Re: Aspect Industrial Estate, Mamre Road – Request for Further Information

The following table provides our response to the request for additional information received from the Department of Planning Industry and Environment (DPIE), Transport for New South Wales (TfNSW), Penrith City Council (Council) and other key stakeholders in relation to SSD-10448.

### Swept Path Analysis

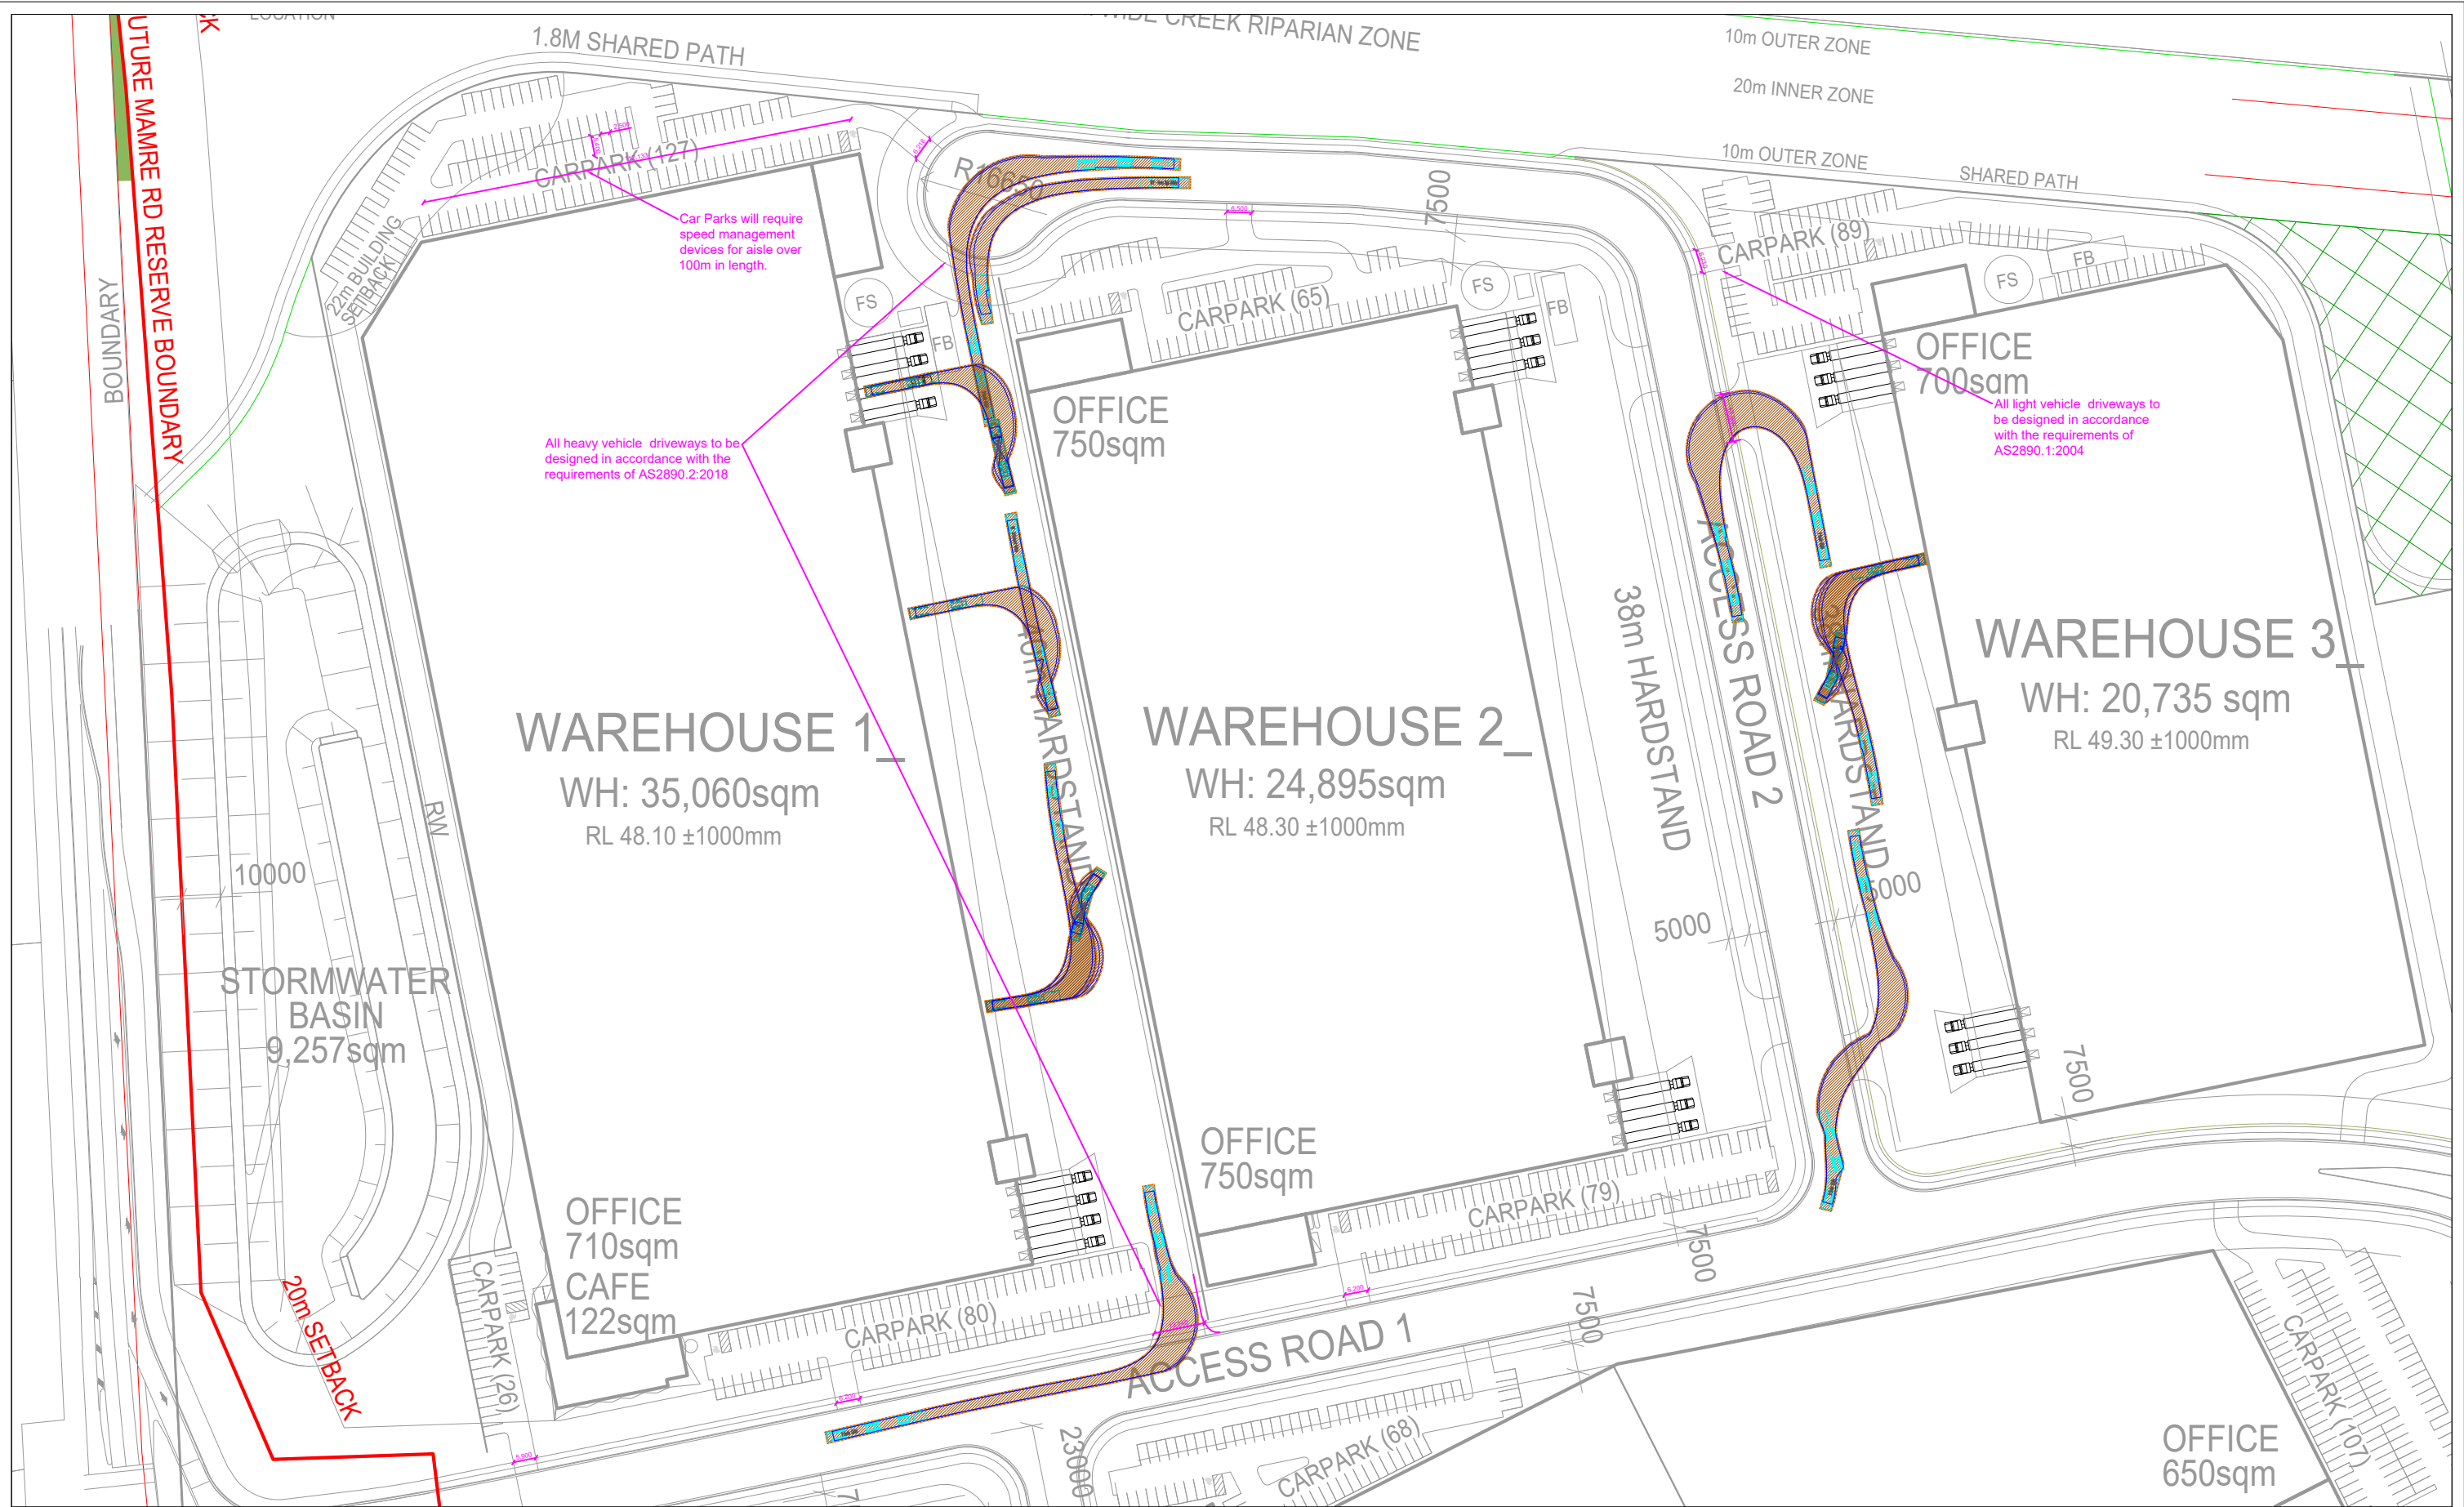
3j.	Appendix F_3 – The swept paths for vehicles egressing Lot 3 on estate road 02 appears to encroach over the centreline of the road in order to achieve the turn. Consideration should be given to widening the driveway access to allow for adequate turn paths to be achieved.	Noted
3k.	The swept paths provided are of a 26m B-Double. Swept paths will be required to be provided to accommodate the largest type of heavy vehicle which could reasonably be expected to service the site. The WSEA SEPP outlines the required vehicle lengths to be accommodated for. In this regard, the design vehicle for the access to the site should be assessed with a 30m PBS 2B vehicle, in addition to the 26m B-Double.	Updated swept paths attached to TMAP
3l.	Appendix B (Preliminary CTMP) – All demolition and construction vehicles are to be contained wholly within the site and vehicles must enter the site before stopping. A construction zone will not be permitted on Mamre Road.	The CTMP has been updated to reflect the requested change.
